DRB CASE ACTION LOG (Preliminary/Final)

DRB Application No.: 11DRB-70173 Project # 1008849
 Project Name: Navajo Addition / Sampson Addition
 Agent: The Survey Office Phone No.: _____

**CITY OF ALBUQUERQUE
PLANNING DEPARTMENT
July 13, 2011
DRB Comments**

**RE: Lot 14, Navaho Addition and Lot 1, Block 1, Sampsell
Addition**

**PLAT OF
LOTS 1 & 2
LANDS OF MAYO ULIBARRI
PROJECTED SECTION 18, T. 10 N., R. 3 E., N.M.P.M.
TOWN OF ALBUQUERQUE GRANT
CITY OF ALBUQUERQUE
BERNALILLO COUNTY, NEW MEXICO
JUNE 2011
SHEET 2 OF 2**

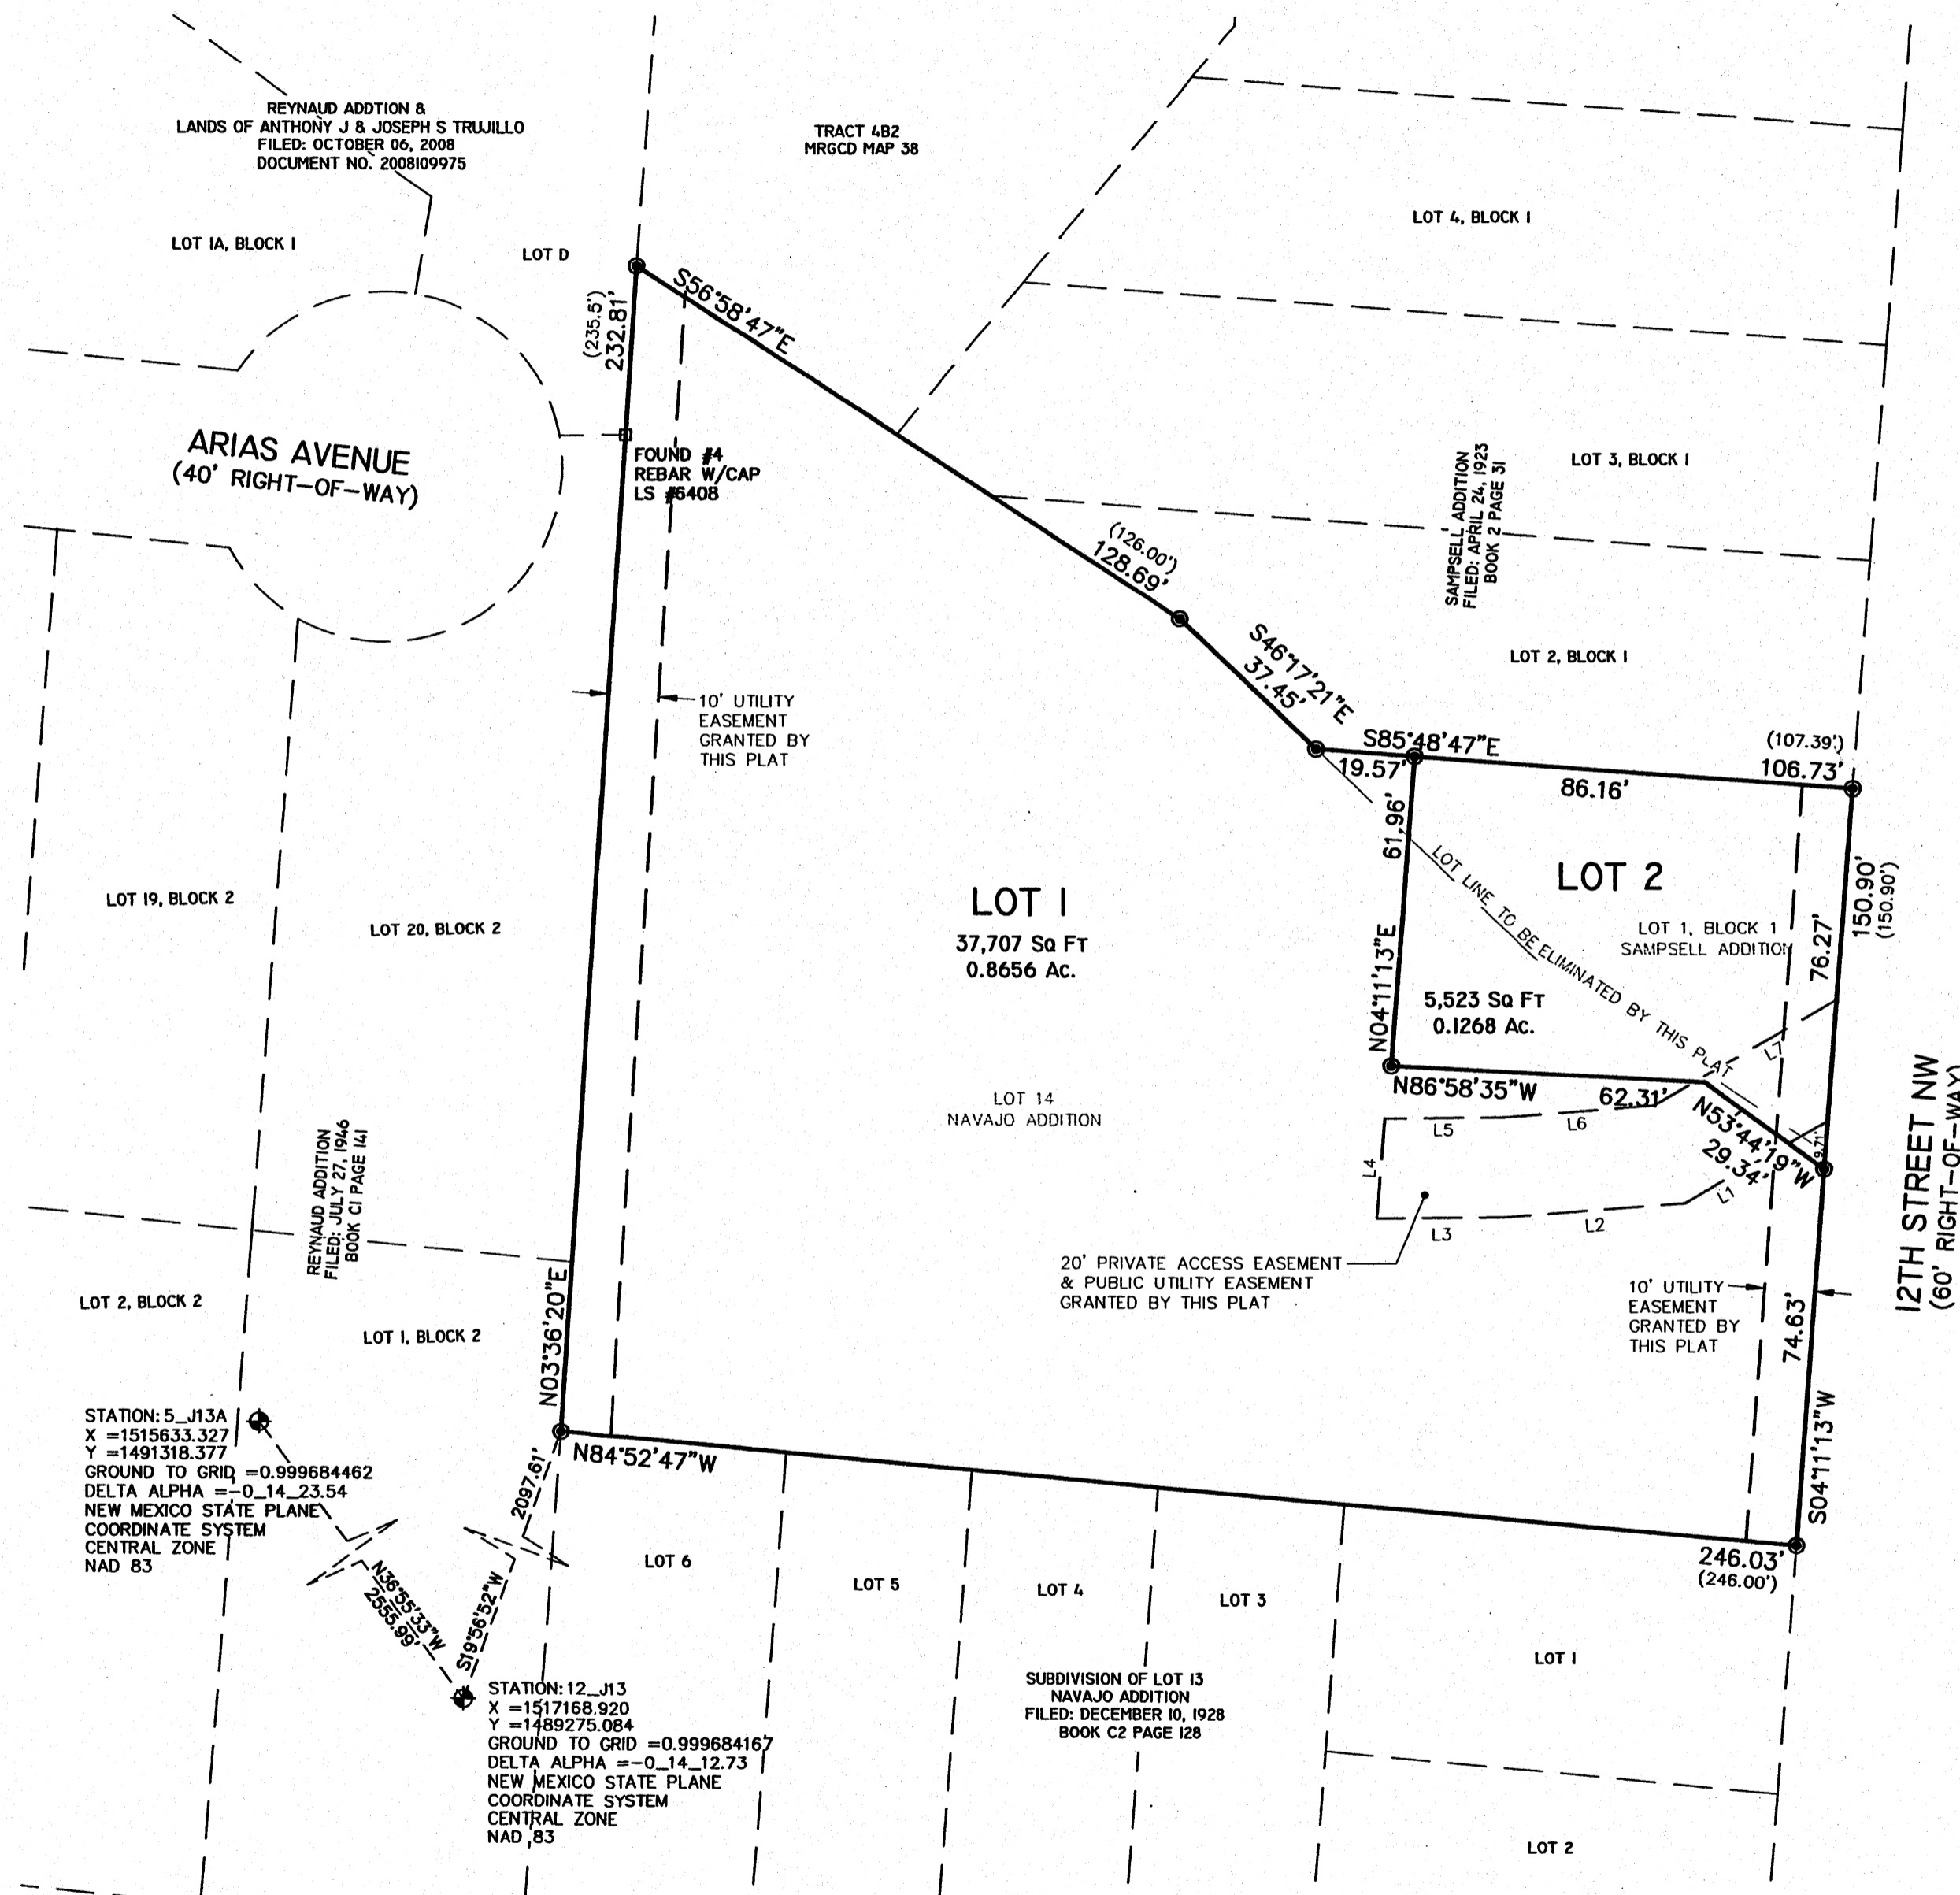
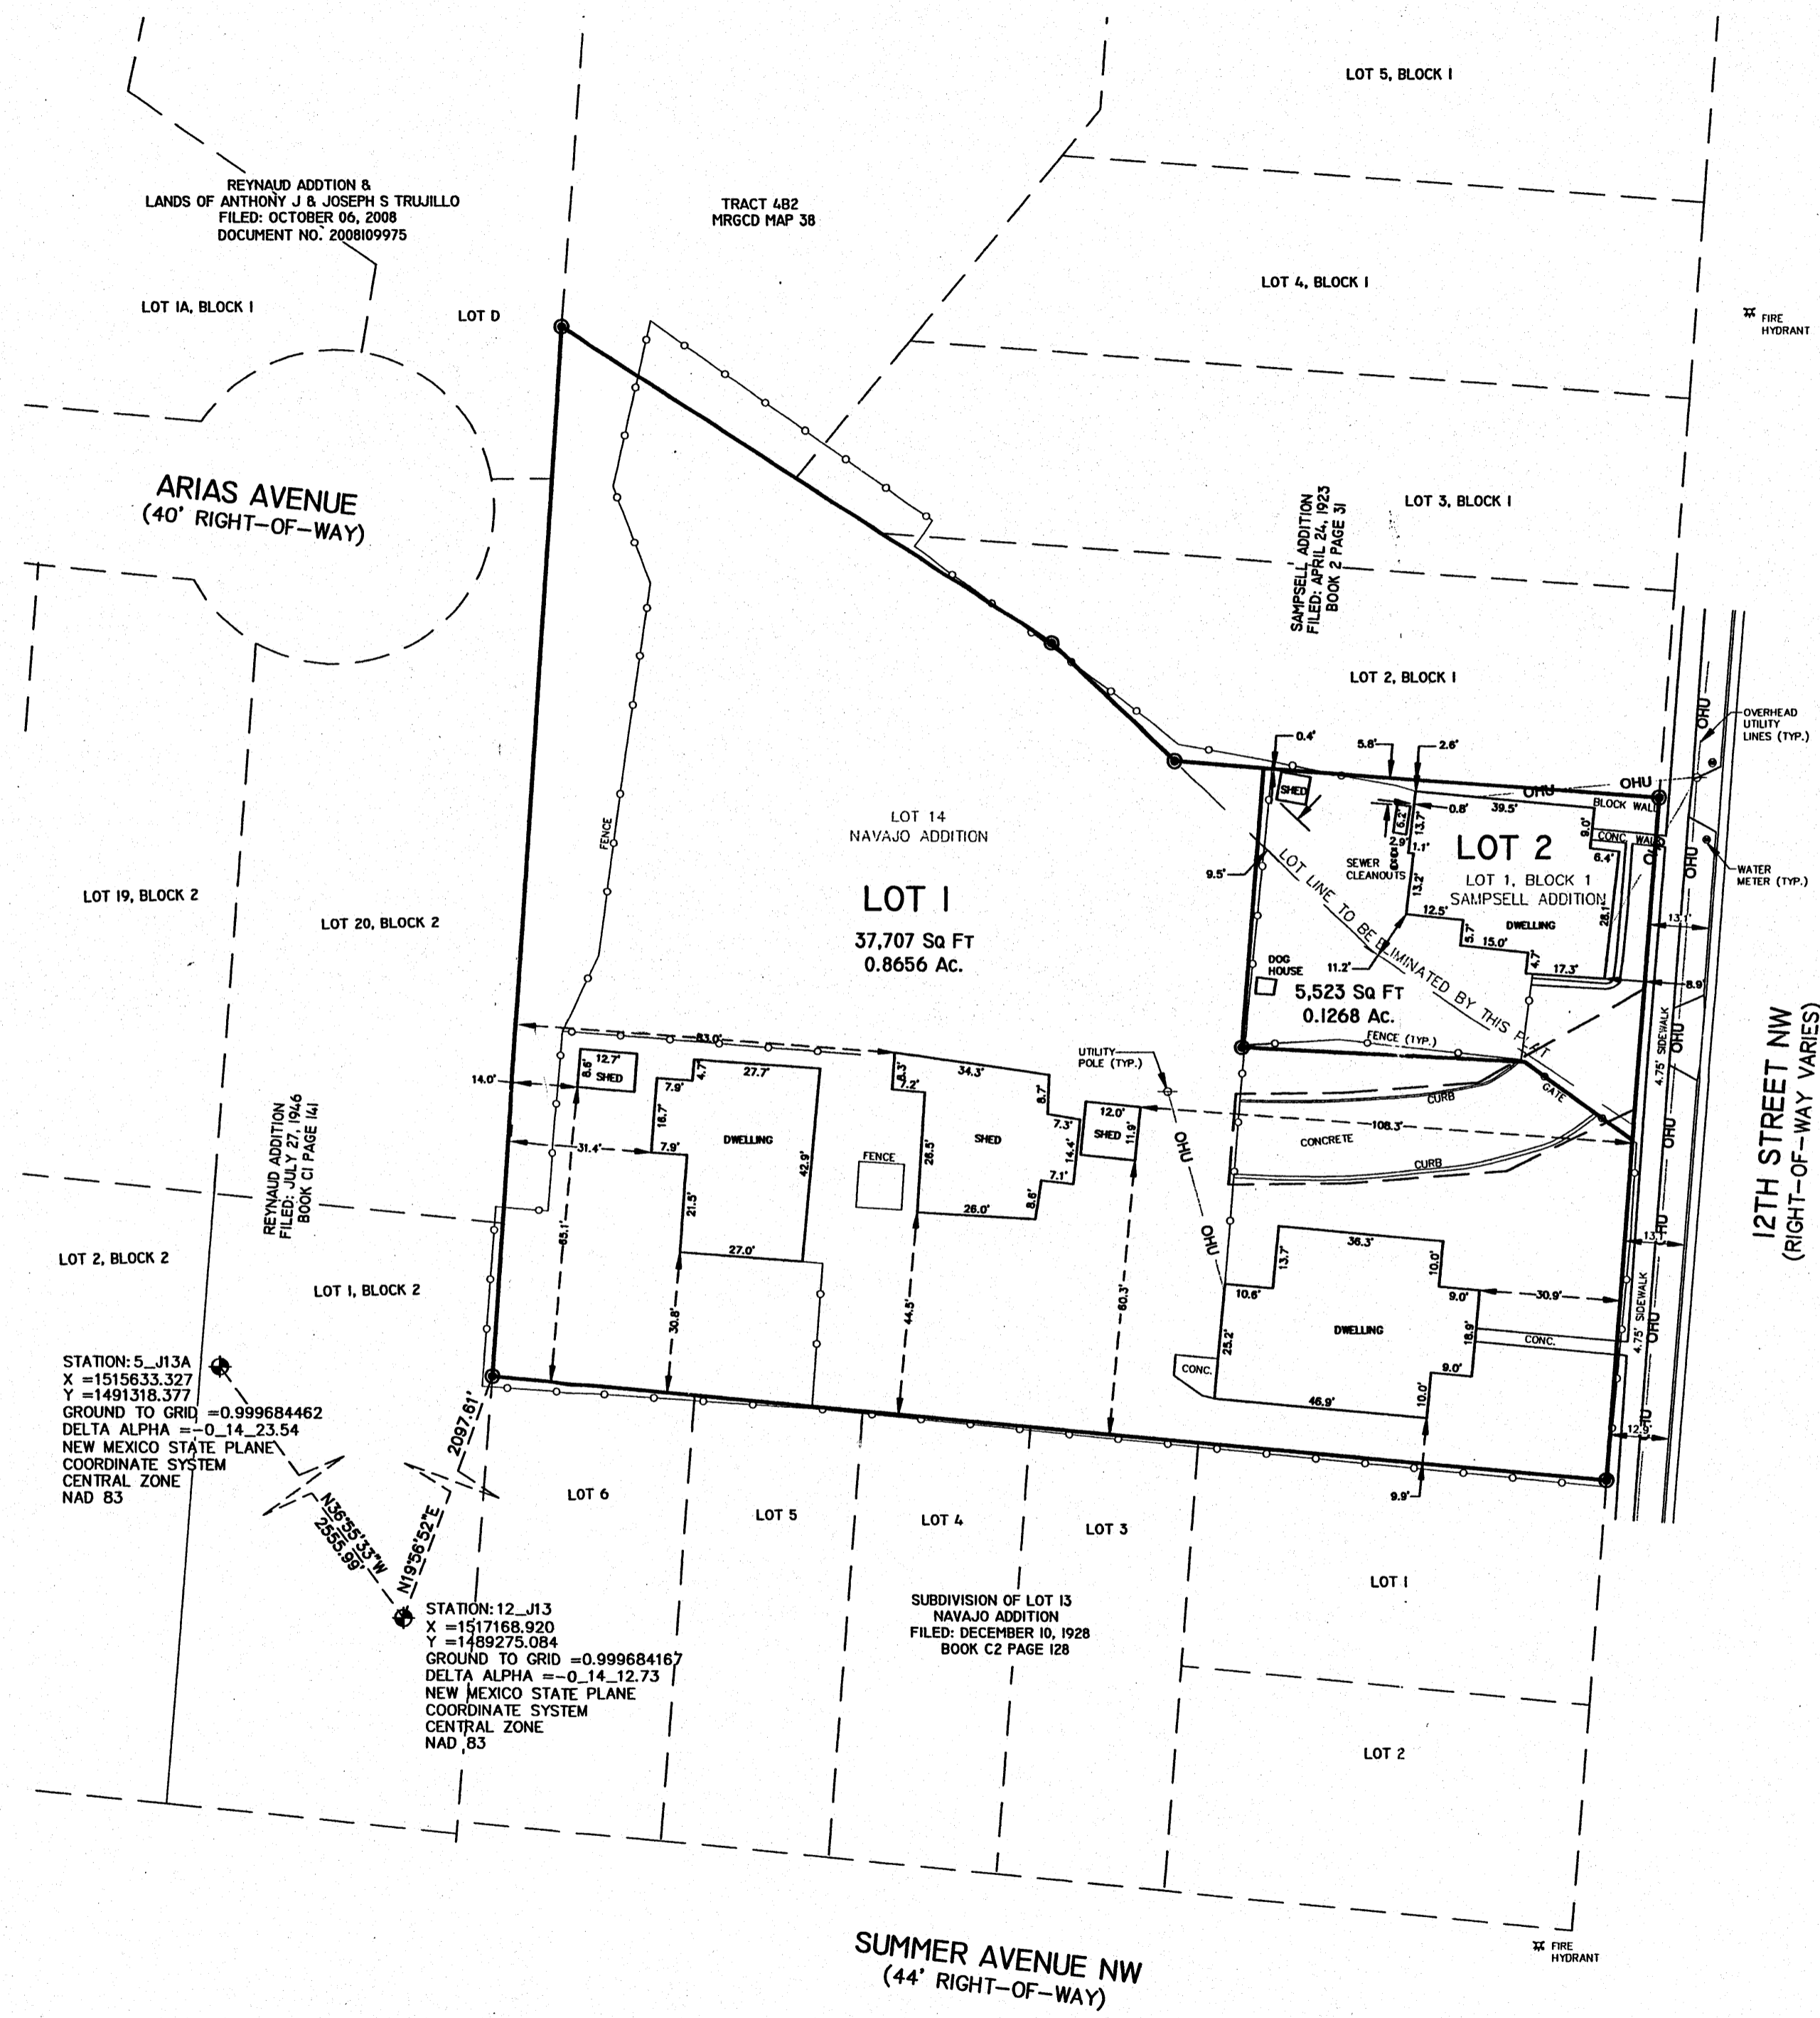
PLANNING (Last to sign): photo of fence removal - revise
Element - maintenance & beneficiaries

THE SURVEY OFFICE agent(s) for MAYO & JEAN ULIBARRI request(s) the above action(s) for all or a portion of Lot(s) 14 & 1, Block(s) 0 & 1, **NAVAJO ADDITION / SAMPSELL ADDITION** zoned S-R, located on 12TH ST NW BETWEEN SAWMILL NW AND SUMMER NW containing approximately .9924 acre(s). (J-13) **THE PRELIMINARY/FINAL PLAT WAS APPROVED WITH FINAL SIGN OFF DELEGATED TO PLANNING FOR A PHOTO OF FENCE REMOVAL AND TO EASEMENT REVISION TO INCLUDE MAINTENANCE AND BENEFICIARIES AND FOR AGIS DXF.**

Please indicate the Net Lot Area (the lot area excluding the Access
Easement area on each lot).
